Your ref. EP/48/21/HH

We are writing in objection to the planning permission for a first-floor dormer to 2 Bay Tree Gardens, East Preston. Our property backs onto the afore mentioned property, to the west.

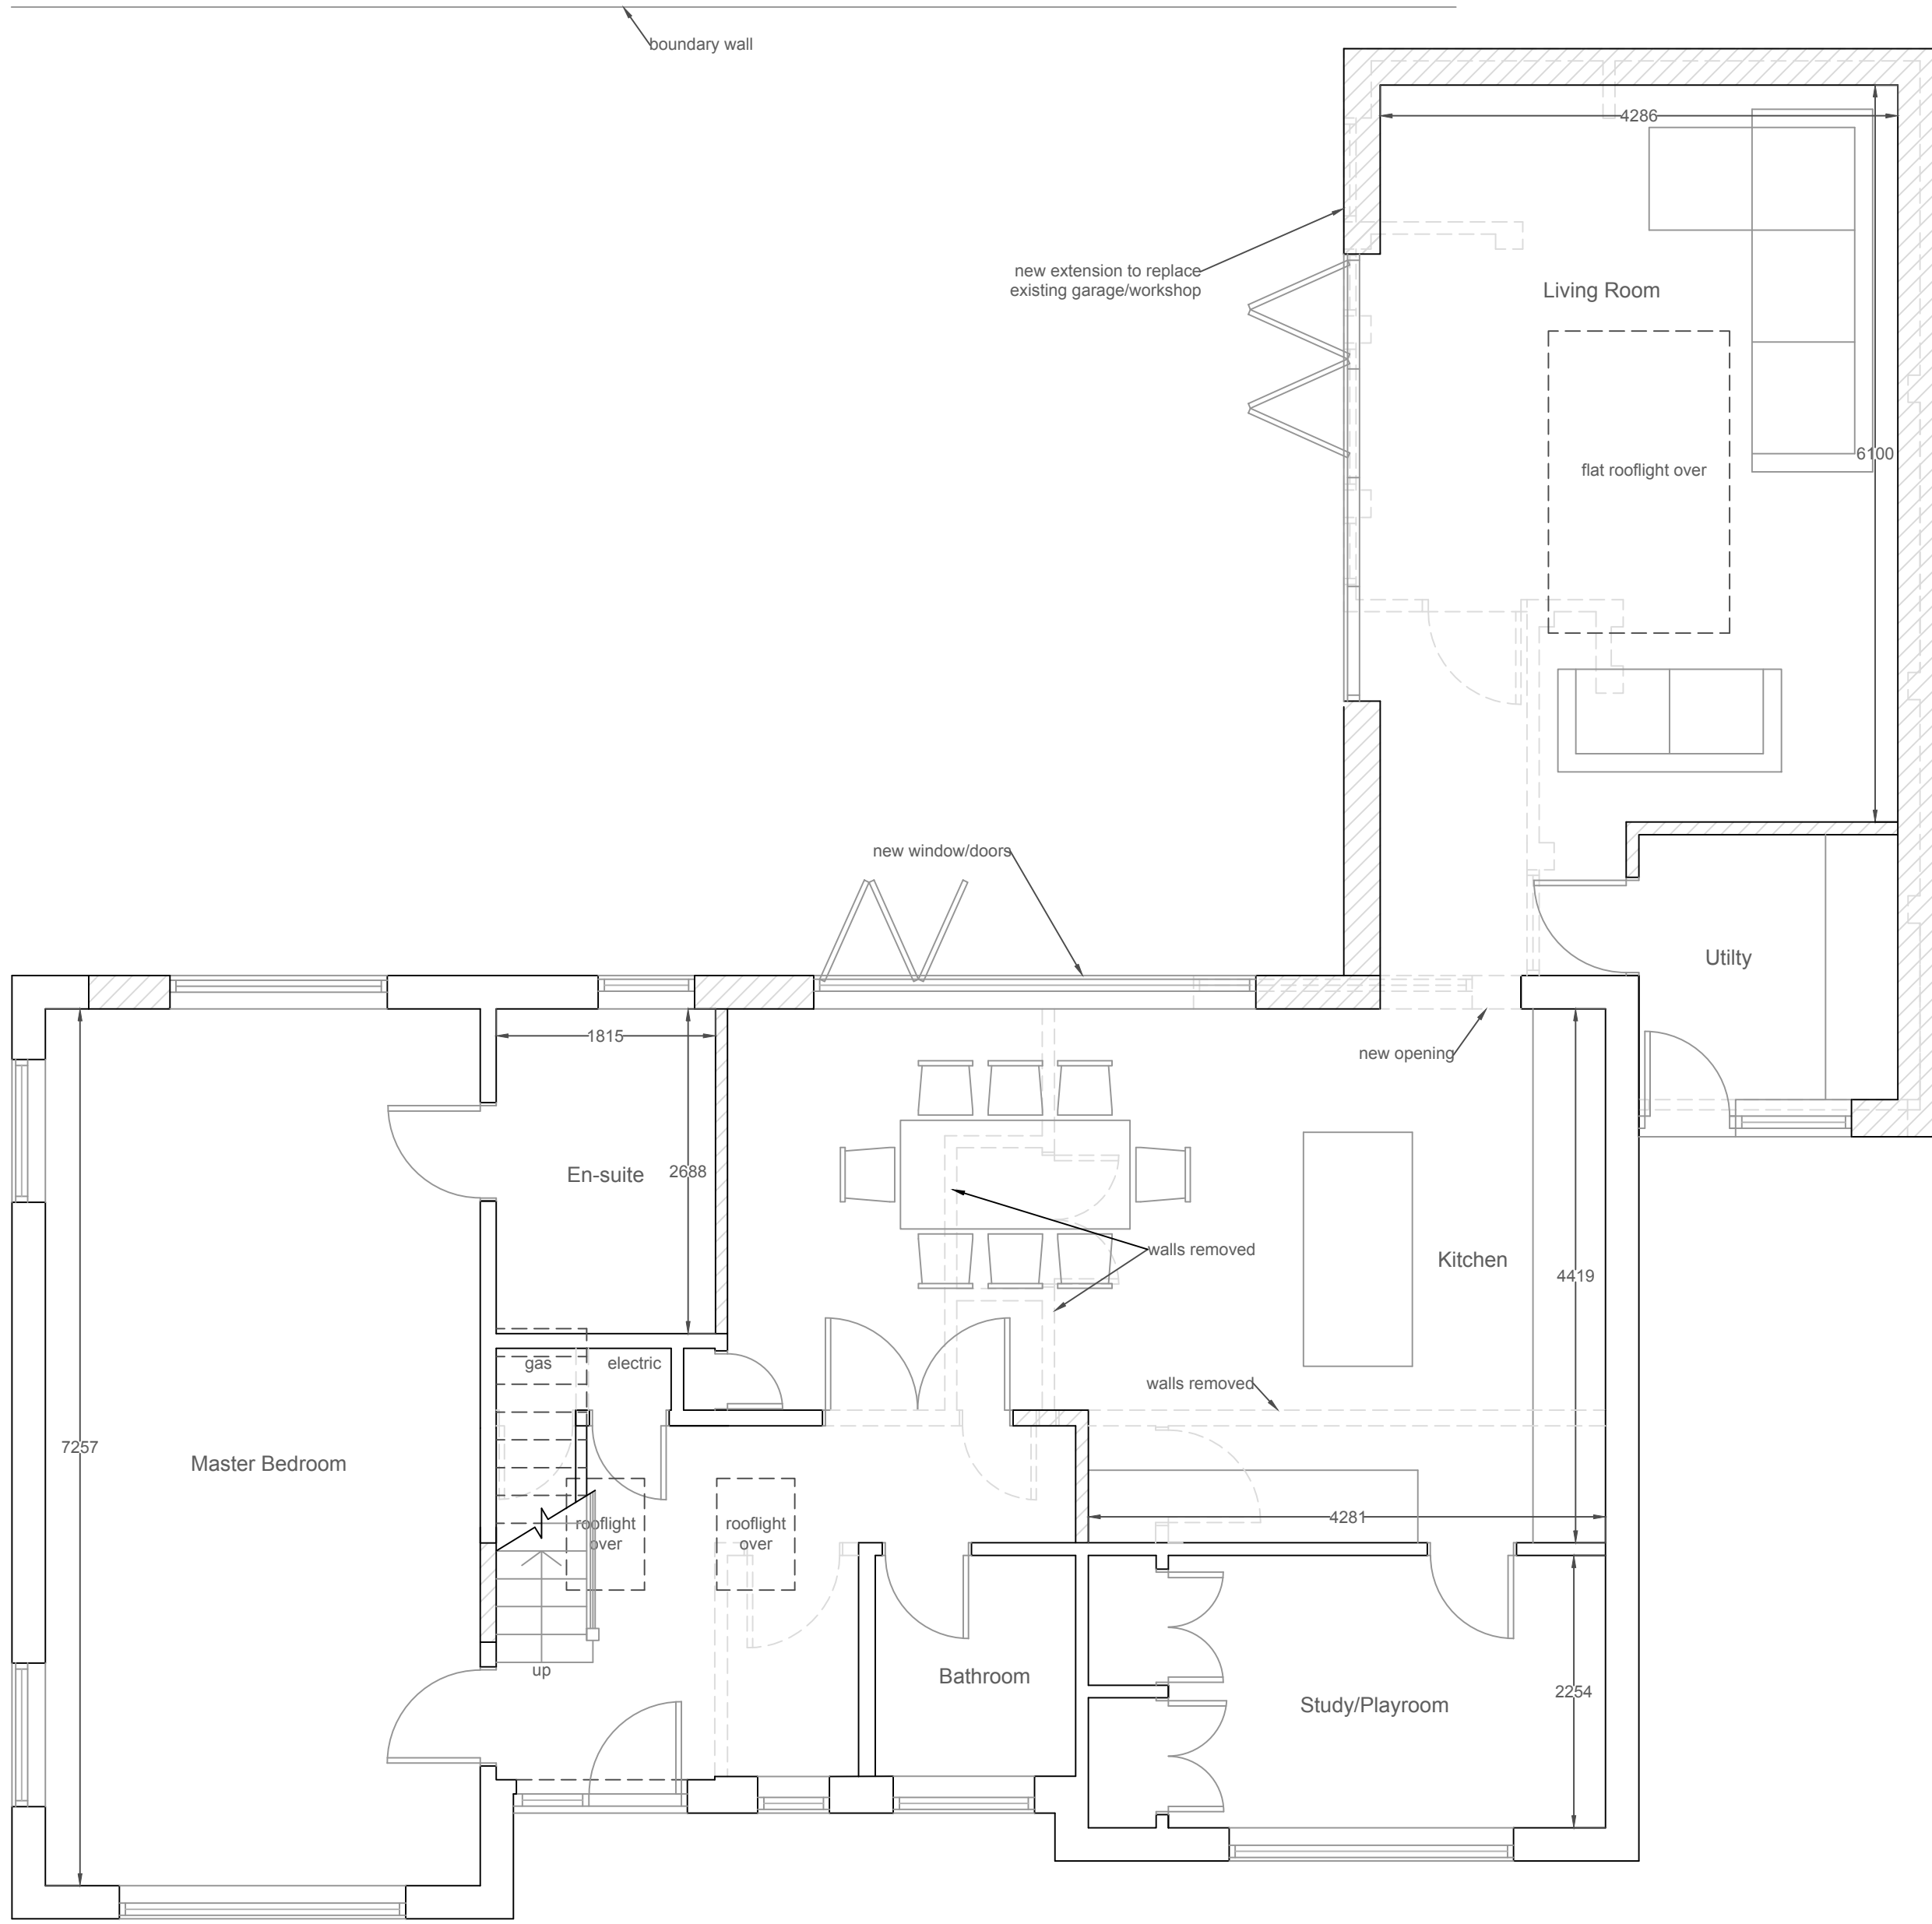
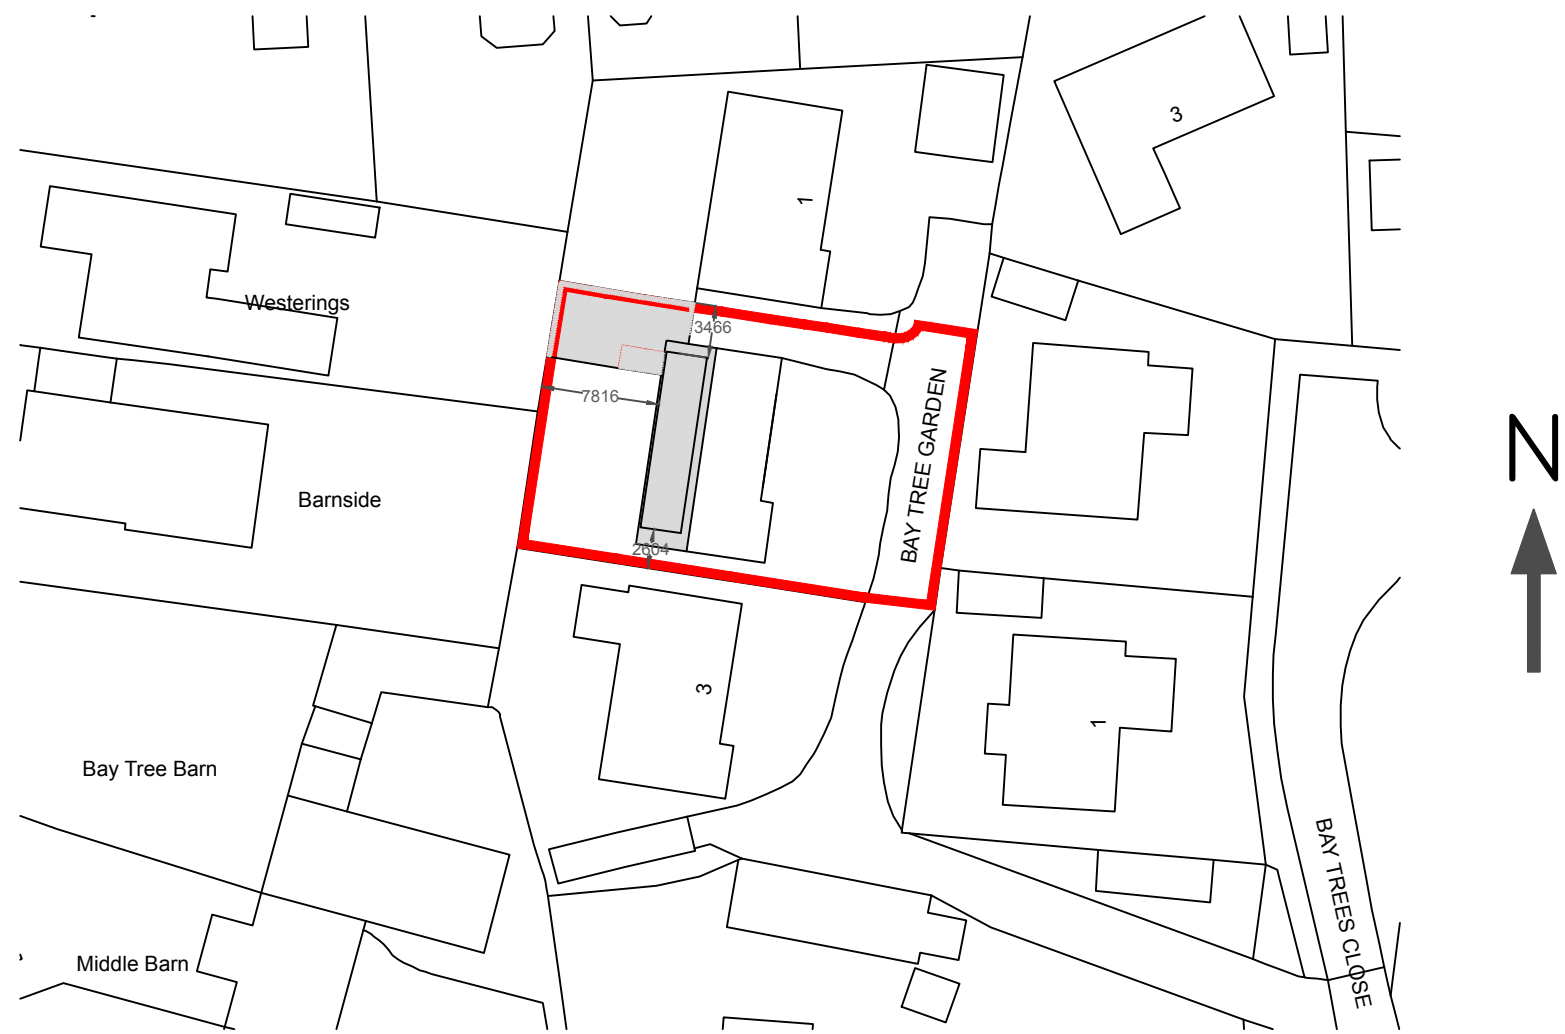
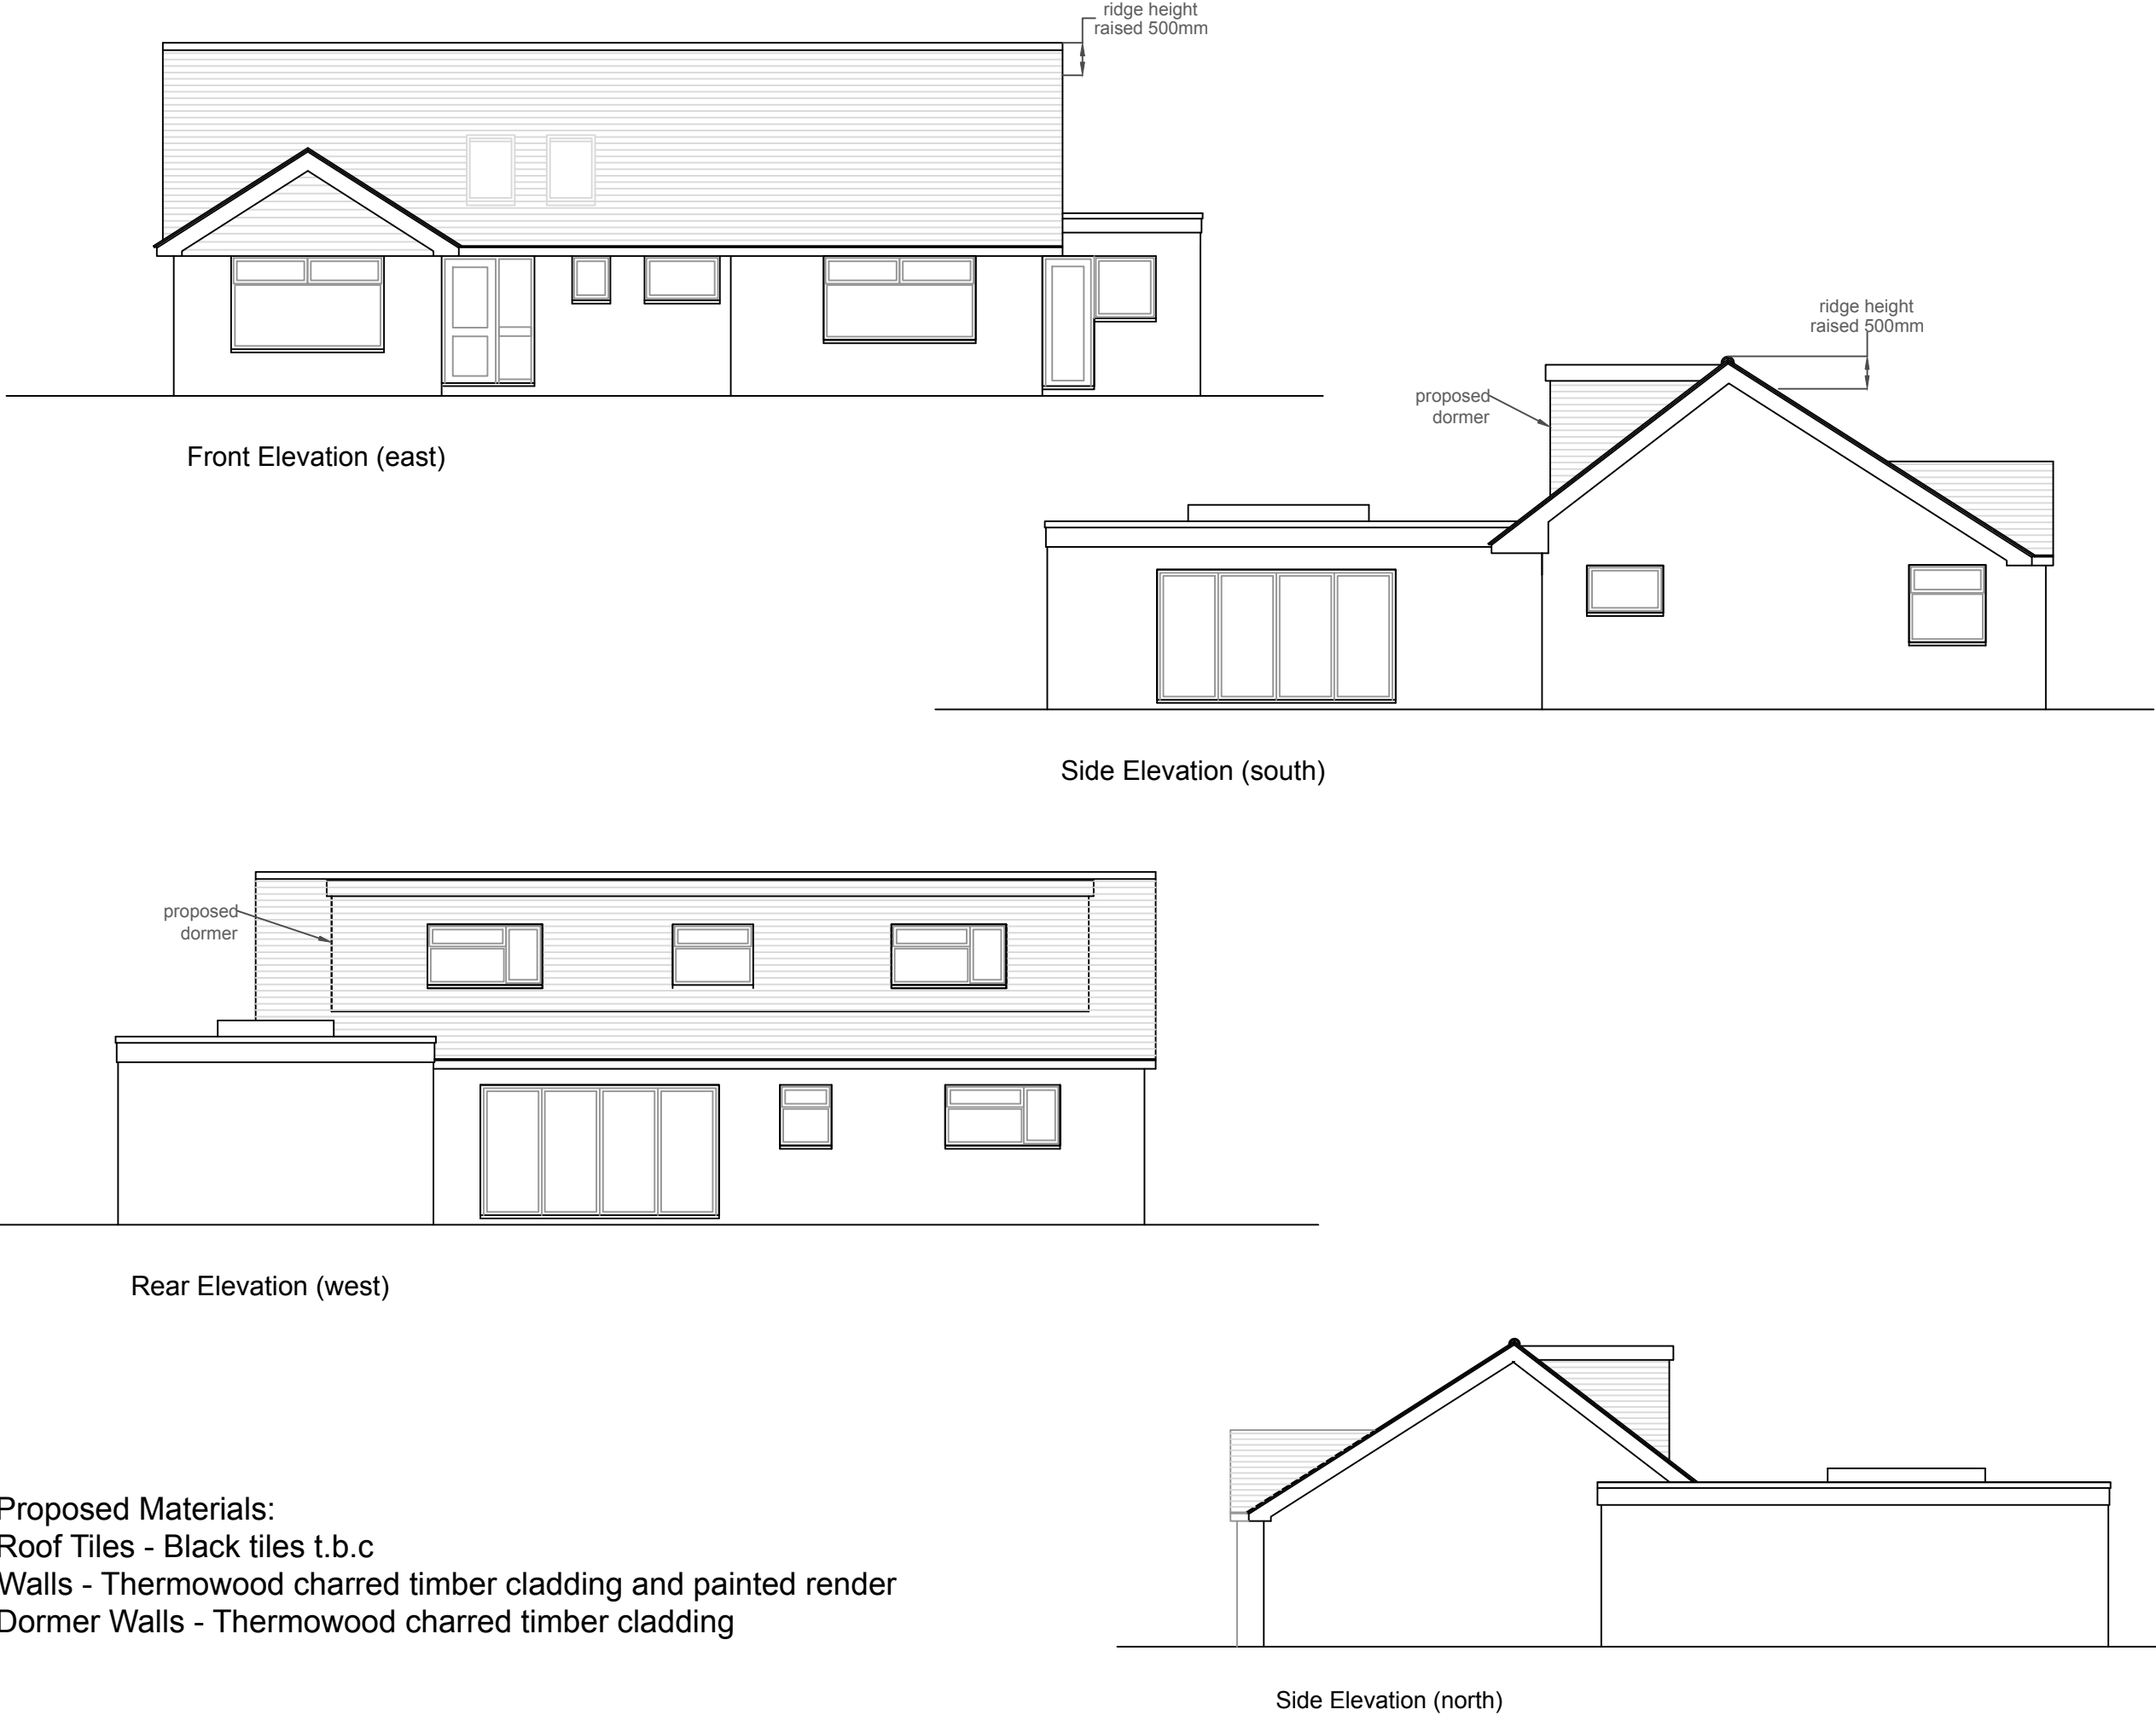
The proposed design of the dormer will overpower the look of the surrounding area due to its size and colour. The cladding of a black burnished wood and black roof tiles are not in keeping or sympathetic with the materials currently used on the external walls of the surrounding dwellings. Surrounding properties have traditional tiled roofs and tiled dormers, with red brick walls. Any deviation from this style, such as the proposed white rendering and black cladding would be in violation of Design Policy 4 of the East Preston Neighbourhood plan for Area 3, which states that:

The proposed dormer is oversized and includes unobscured windows that would look directly into our conservatory, dining room, kitchen, and master bedroom. In addition, it would overlook an established decking area at the bottom of our garden, which the

The proposals to raise the roof would make the property stand out in the row of three bungalows and would not compliment the scale or massing of the surrounding buildings. Therefore, the proposed extension to 2 Bay Trees Gardens is in conflict with Policy D DM4 of the Arun Local Plan 2011-2031.
